Application for a non-material amendment following a grant of planning permission.
Town and Country Planning Act 1990

SINGLE STOREY REAR EXTENSIONS

A/80/21/HH

INCREASE OF BOTH REAR PROJECTIONS BY 300mm

sheet 1 b of 2

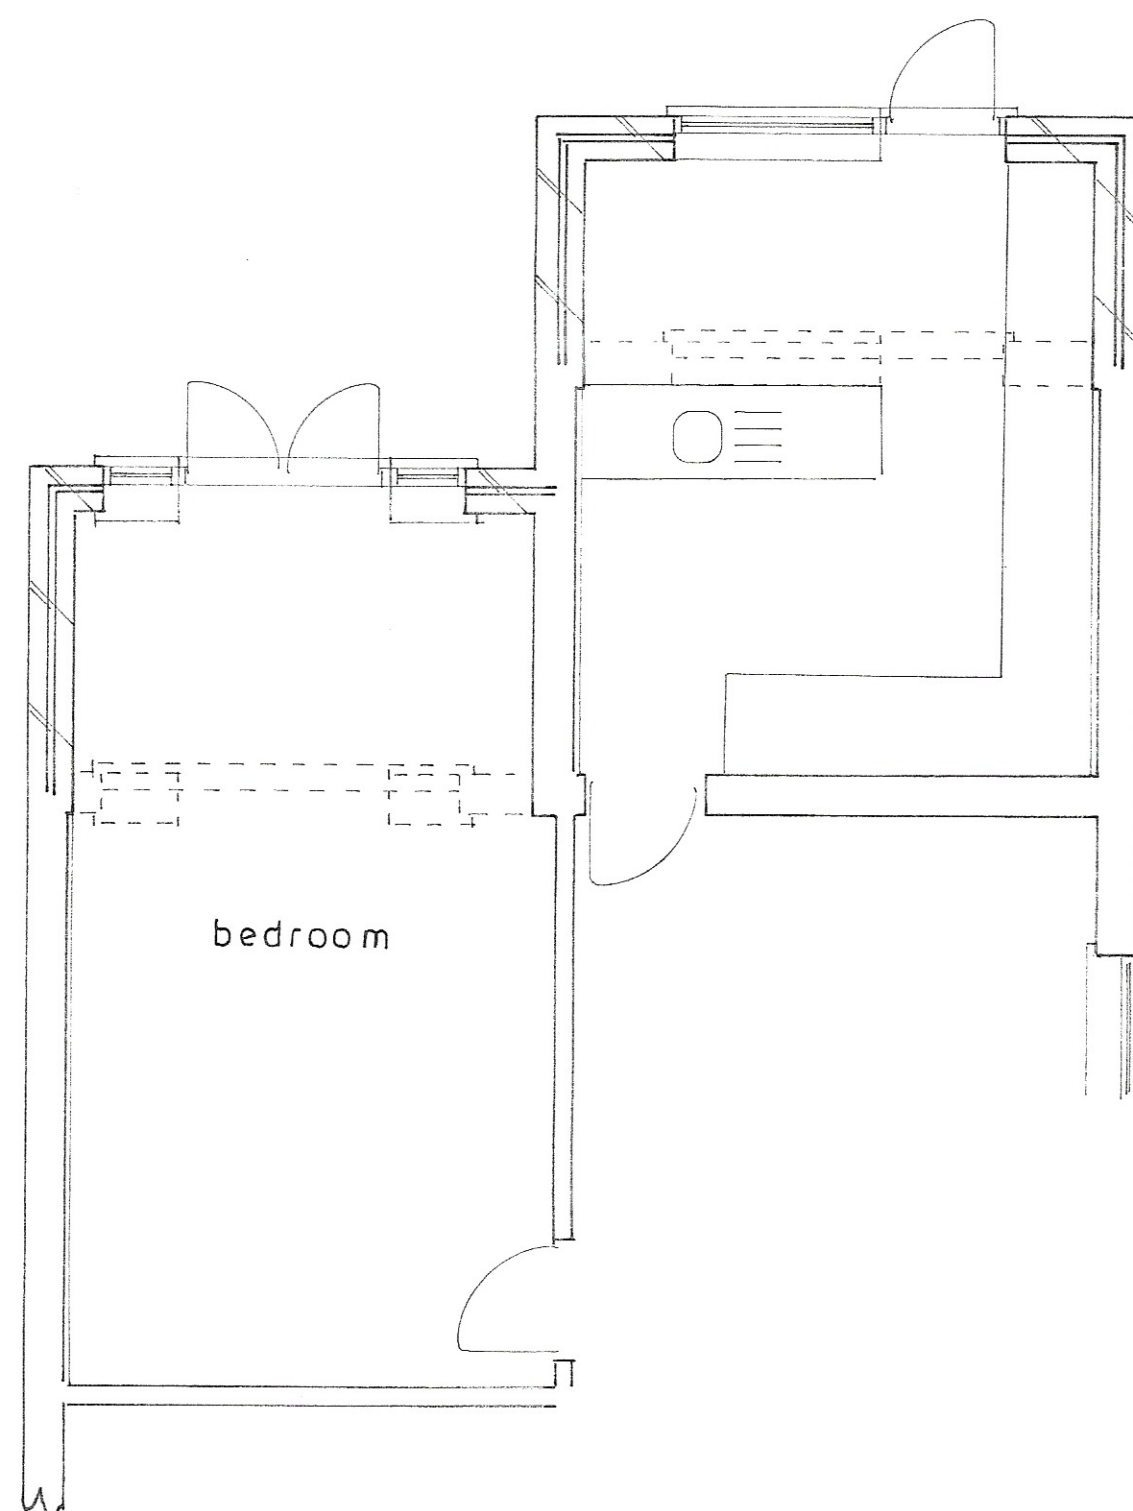
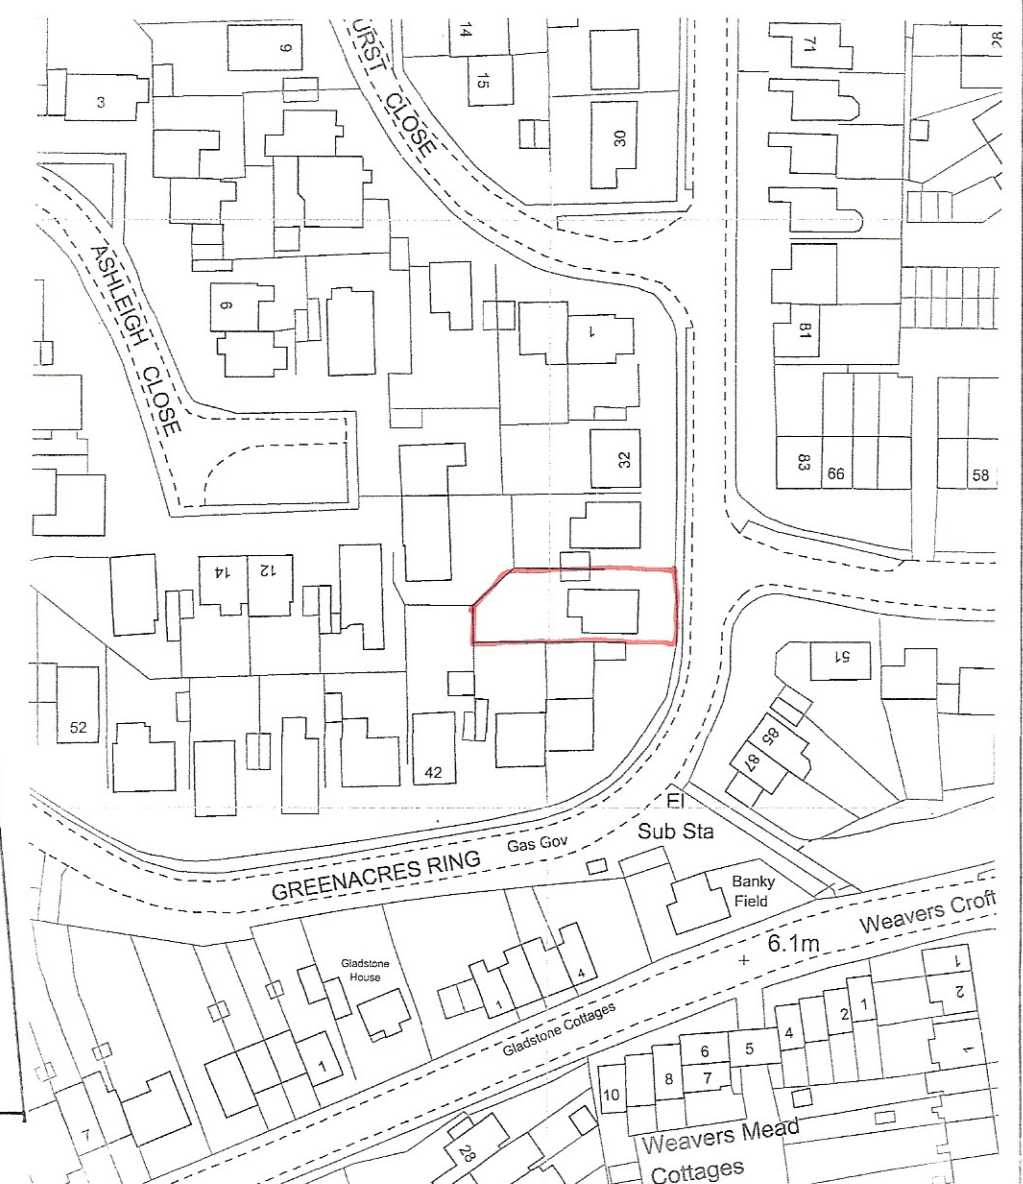
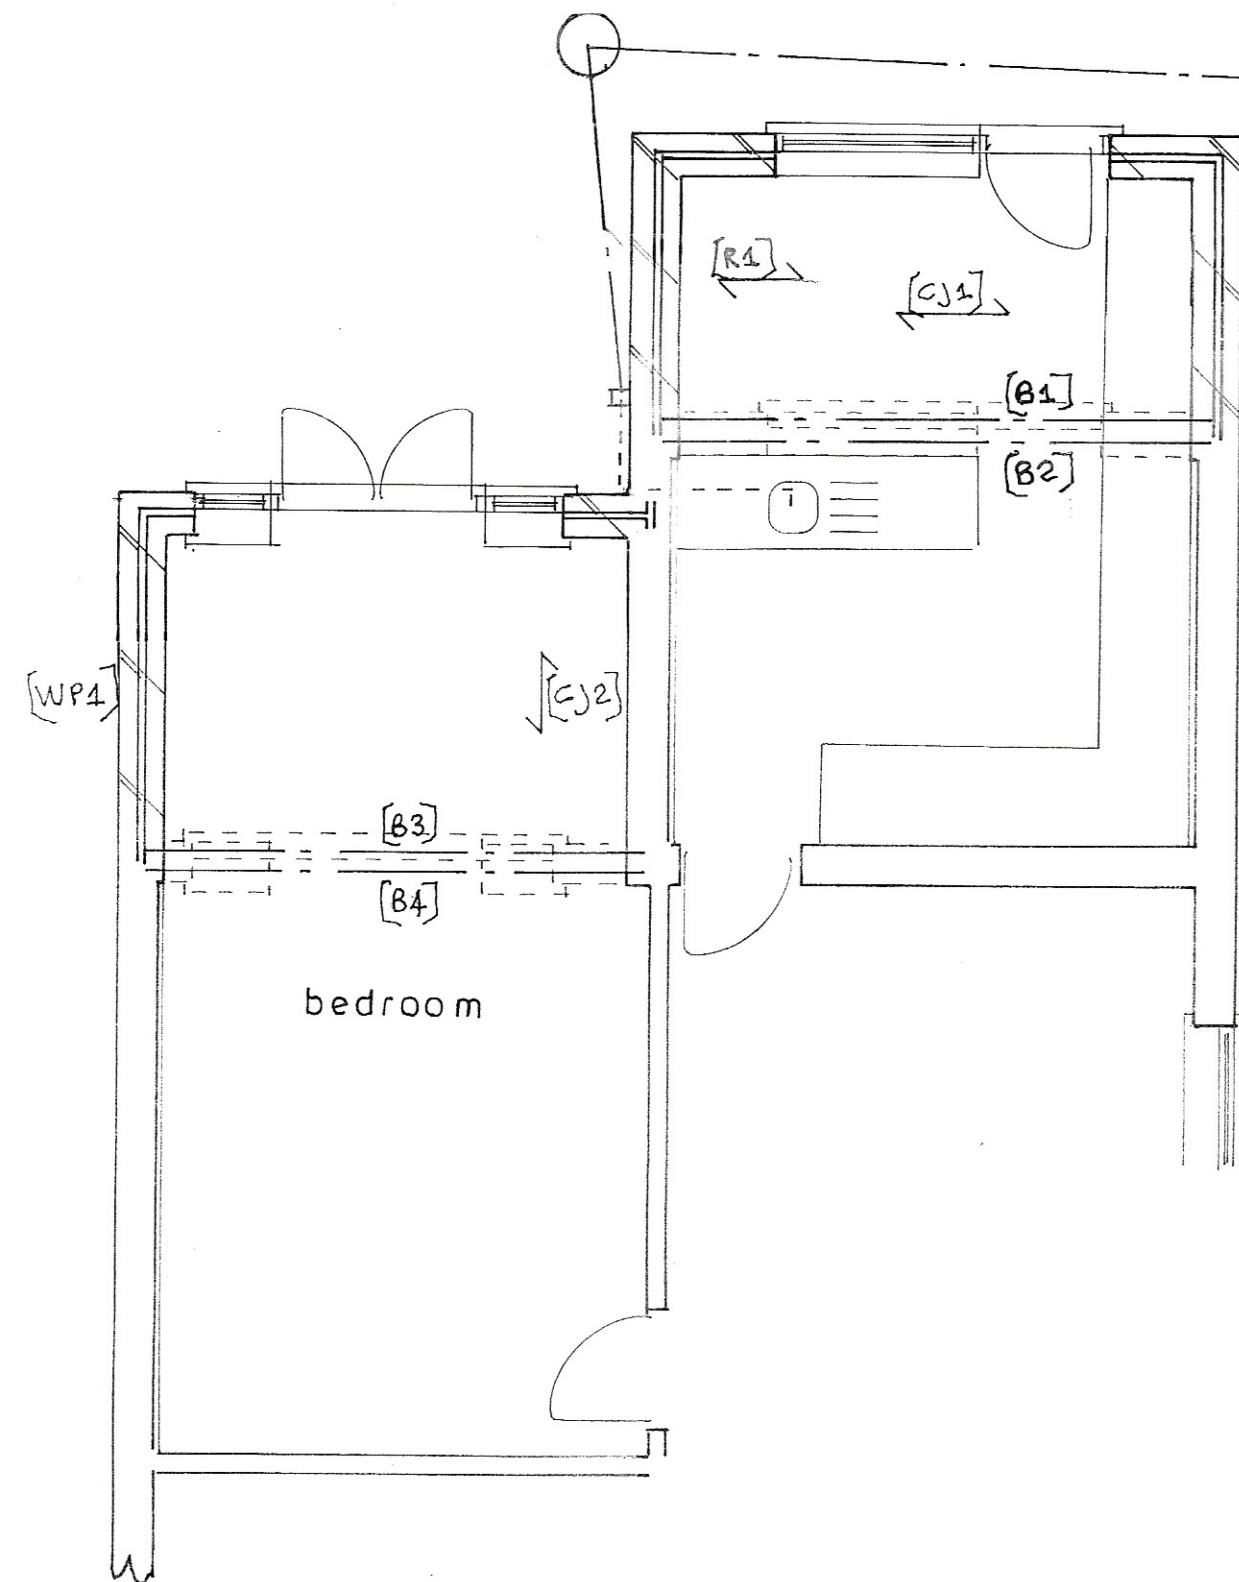
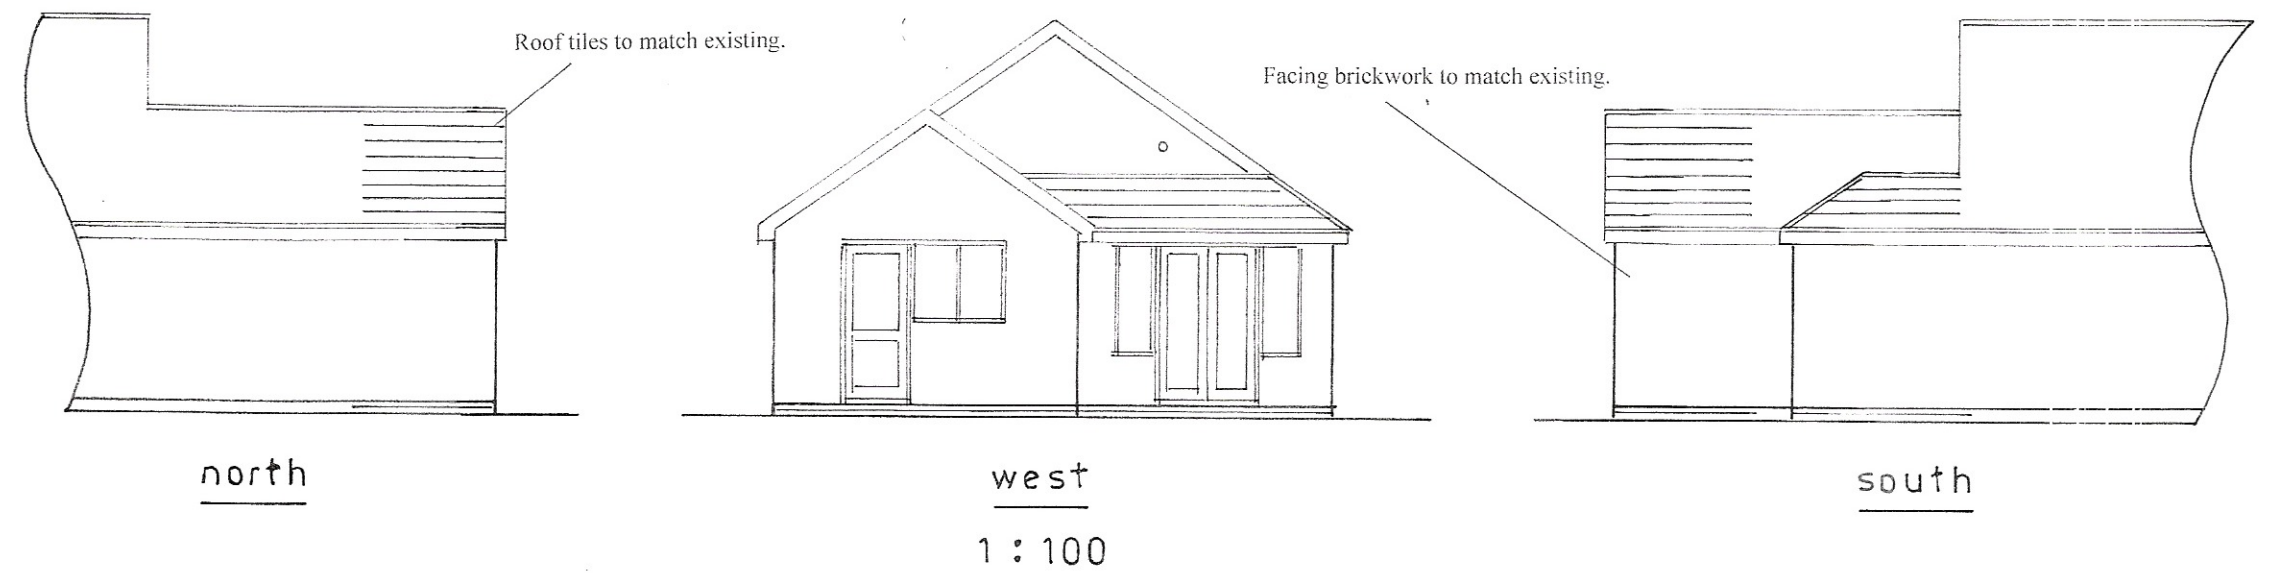
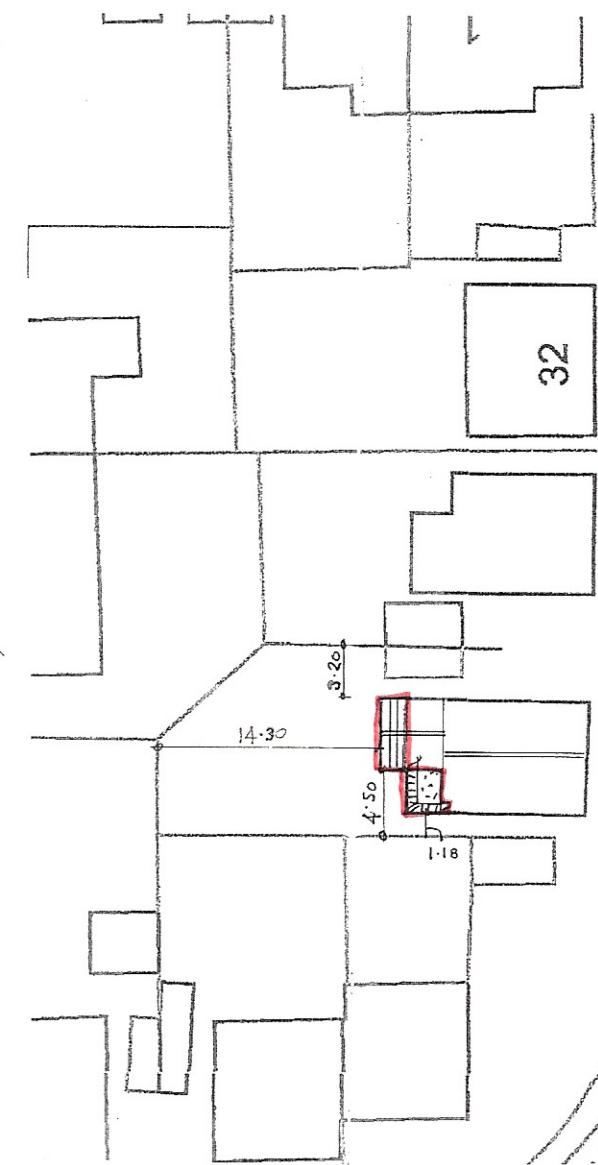
SHEET 1 of 2 + SHEET 2 of 2

SHEET 1b of 2 + SHEET 2a of 2
